**Tillbridge Solar Project
EN010142**

**Volume 9
Statement of Common Ground with Natural
England**

Document Reference: EN010142/APP/9.18

**October 2024
Revision Number: 00**

**FIGURE NUMBER**  
Figure 15-1

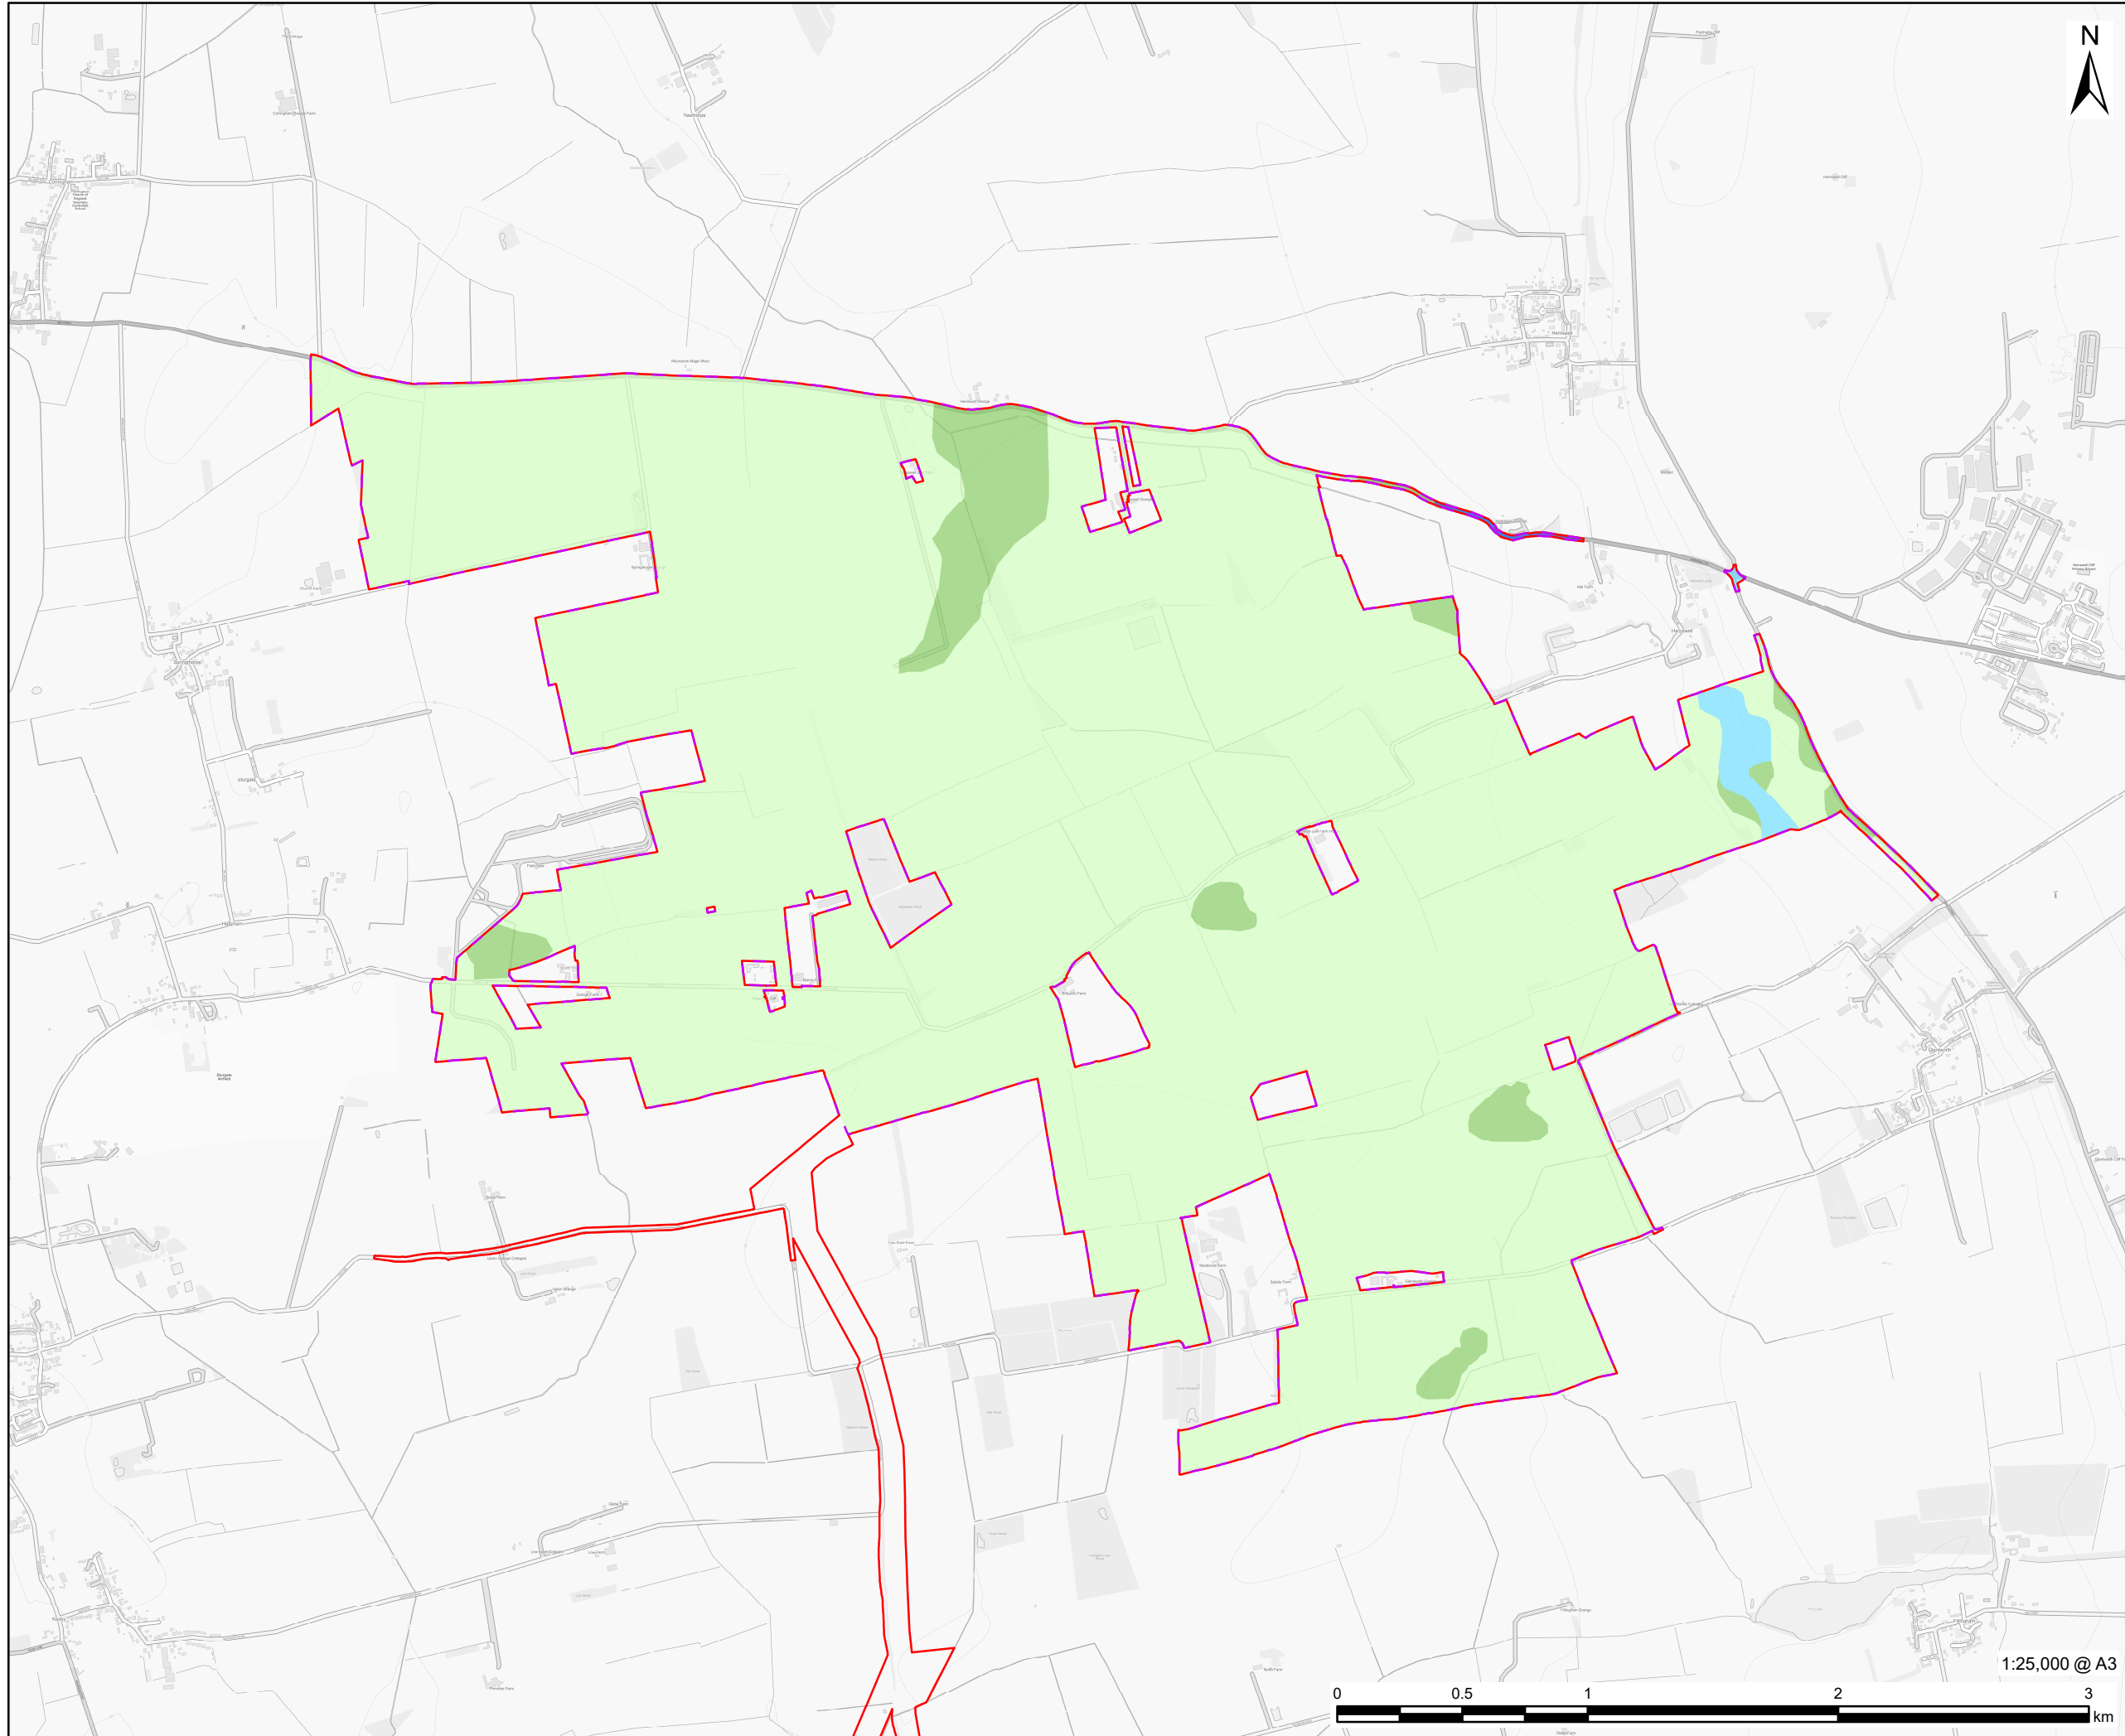
2.2	Chapter 15: Soils and Agriculture [APP-046]	<p><u>NE's Comment:</u> <i>NE14 - Soils and best and most versatile agricultural land</i> <i>Categorising of significance of BMV (C), (O), (D)</i> Chapter 15, paragraph 15.4.21- Natural England note development that has or could potentially lead to the permanent loss of more than 20ha of Best and Most Versatile Agricultural land is 'significant'. Ensure permanent losses of >20ha BMV are considered as significant.</p> <p><u>Applicant's Response</u> As set out within Section 15.8 of Chapter 15: Soils and Agriculture of the ES [APP-046], the Scheme will not result in the permanent loss of an area of greater than or equal to 20ha BMV land. The Applicant submitted a Change Request application on 27 September 2024, which reduced the overall area of the Principal Site by approximately 5ha. The areas excluded from the Order limits mostly included non-agricultural and Grade 3b land.</p>	Under discussion	High

Ref.	Relevant Application Document	Description of Matter	Status	Likelihood of Resolution																																																				
		<p>Tables I and II below provide a simple summary of the ALC grade breakdown at the Principal Site within the format requested by Natural England.</p> <p>Table I: Updated ALC Grade Distribution within the Principal Site</p> <table border="1"> <thead> <tr> <th>ALC Grade</th> <th>Total Area (ha)</th> </tr> </thead> <tbody> <tr> <td>Grade 2</td> <td>9.2</td> </tr> <tr> <td>Grade 3a</td> <td>51.1</td> </tr> <tr> <td>Grade 3b</td> <td>1151.1</td> </tr> <tr> <td>Non-Agricultural</td> <td>133.4</td> </tr> <tr> <td>Total</td> <td>1,344.8</td> </tr> </tbody> </table> <p>Table II: Updated ALC Grade of the Principal Site Components</p> <table border="1"> <thead> <tr> <th rowspan="2">Principal Site Component</th> <th rowspan="2">Temporary/ Permanent</th> <th>Grade 2</th> <th>Grade 3a</th> <th>Grade 3b</th> <th>Total</th> </tr> <tr> <th>Area (ha)</th> <th>Area (ha)</th> <th>Area (ha)</th> <th>Area (ha)</th> </tr> </thead> <tbody> <tr> <td>Solar Panels</td> <td>Temporary</td> <td>-</td> <td>24.0</td> <td>686.0</td> <td>710</td> </tr> <tr> <td>Solar Stations and BESS</td> <td>Temporary</td> <td>-</td> <td>0.2</td> <td>23.1</td> <td>23.2</td> </tr> <tr> <td>Temporary Construction Compounds</td> <td>Temporary</td> <td>-</td> <td>-</td> <td>2.0</td> <td>2</td> </tr> <tr> <td>Solar Farm Control Centre and Storage</td> <td>Temporary</td> <td>-</td> <td>-</td> <td>0.2</td> <td>0.2</td> </tr> <tr> <td>On-site Substations</td> <td>Permanent</td> <td>-</td> <td>-</td> <td>2.5</td> <td>2.5</td> </tr> </tbody> </table>	ALC Grade	Total Area (ha)	Grade 2	9.2	Grade 3a	51.1	Grade 3b	1151.1	Non-Agricultural	133.4	Total	1,344.8	Principal Site Component	Temporary/ Permanent	Grade 2	Grade 3a	Grade 3b	Total	Area (ha)	Area (ha)	Area (ha)	Area (ha)	Solar Panels	Temporary	-	24.0	686.0	710	Solar Stations and BESS	Temporary	-	0.2	23.1	23.2	Temporary Construction Compounds	Temporary	-	-	2.0	2	Solar Farm Control Centre and Storage	Temporary	-	-	0.2	0.2	On-site Substations	Permanent	-	-	2.5	2.5

ALC Grade	Total Area (ha)																																																							
Grade 2	9.2																																																							
Grade 3a	51.1																																																							
Grade 3b	1151.1																																																							
Non-Agricultural	133.4																																																							
Total	1,344.8																																																							
Principal Site Component	Temporary/ Permanent	Grade 2	Grade 3a	Grade 3b	Total																																																			
		Area (ha)	Area (ha)	Area (ha)	Area (ha)																																																			
Solar Panels	Temporary	-	24.0	686.0	710																																																			
Solar Stations and BESS	Temporary	-	0.2	23.1	23.2																																																			
Temporary Construction Compounds	Temporary	-	-	2.0	2
